Recommendation Report for Planning Permission

REF NO: F/25/21/PL

LOCATION: 8 Beagle Drive
Ford
BN18 0NY

PROPOSAL: Retention of prefabricated concrete workshop at rear with rear access onto Lewis Lane & realignment of the rear boundary (resubmission following F11/21/PL). This application is in CIL Zone 2 (Zero Rated) as other development.

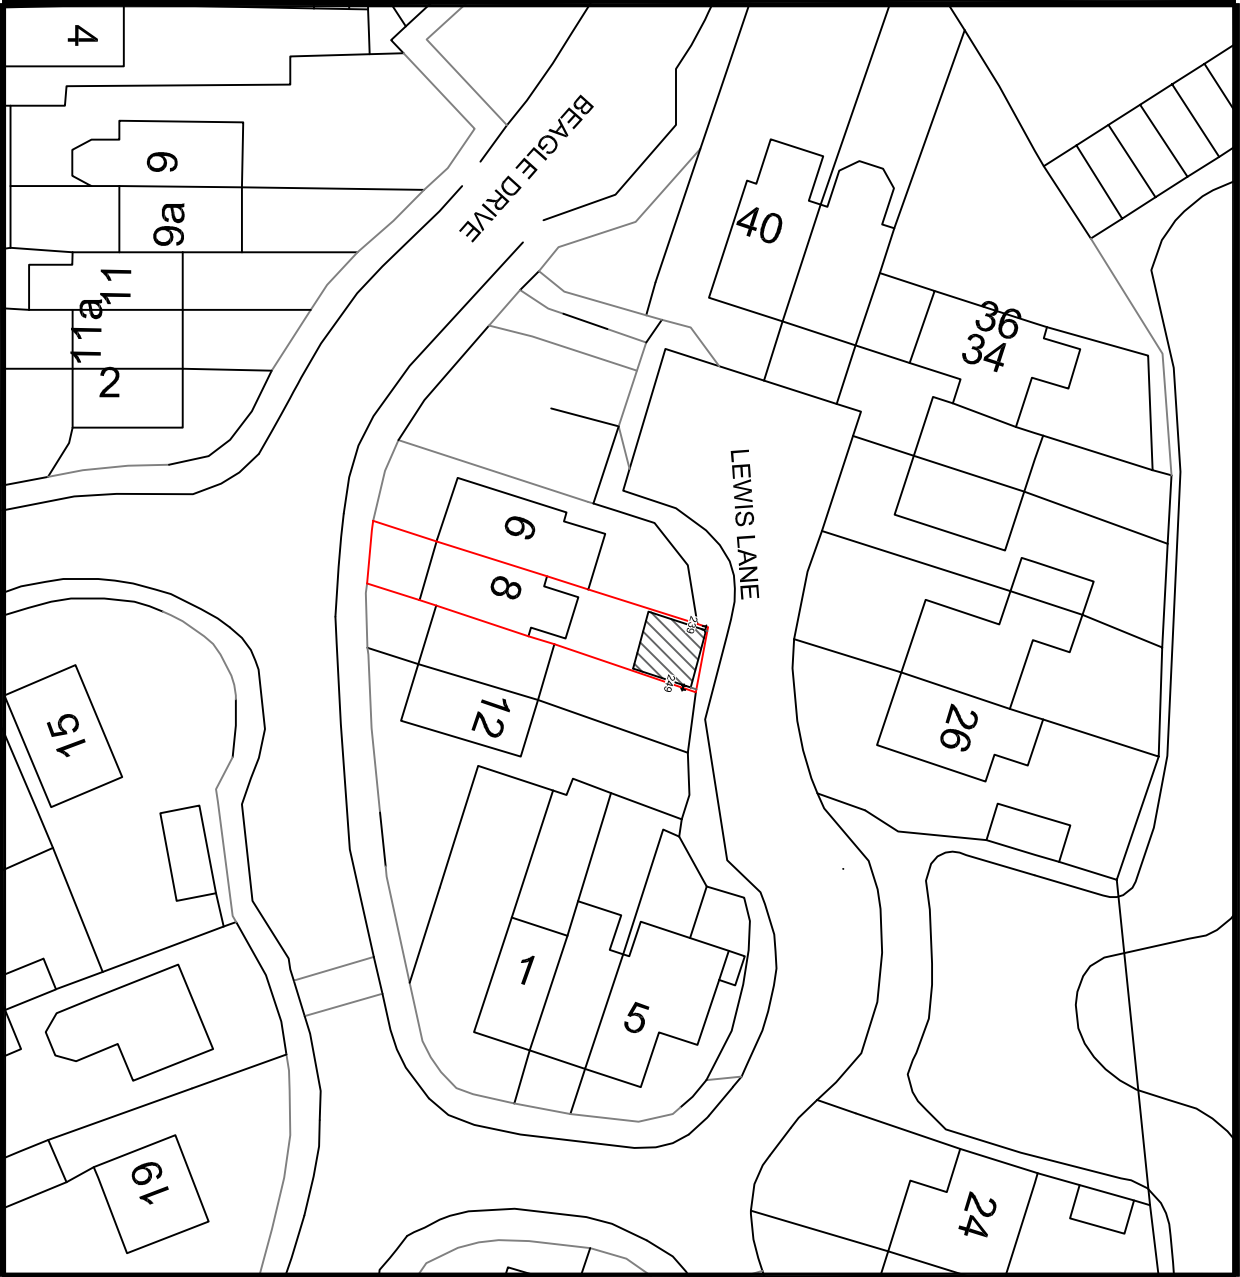
Comments from highways state that the workshop may be partially positioned on highways land (grass verge), the application redline does include the grass verge. Measurements from submitted plans suggest that the building is a maximum of 1.6m from the edge of the highway and as such the section of highway now forming part of the footprint of the workshop site will require a formal application to 'stop up' the area. An informative will be attached to this decision notifying the applicant of their responsibilities.

- 3 **INFORMATIVE:** If it is determined that the workshop building does obstruct public highway, the applicant would be advised that the land subject of this application which is considered to be publicly maintained highways should be formally stopped up via the appropriate legal mechanism. The applicant would be advised to contact WSCC Legal Services to find out further information about the Stopping Up procedure and how to commence an application.
Email: legal.services@westsussex.gov.uk
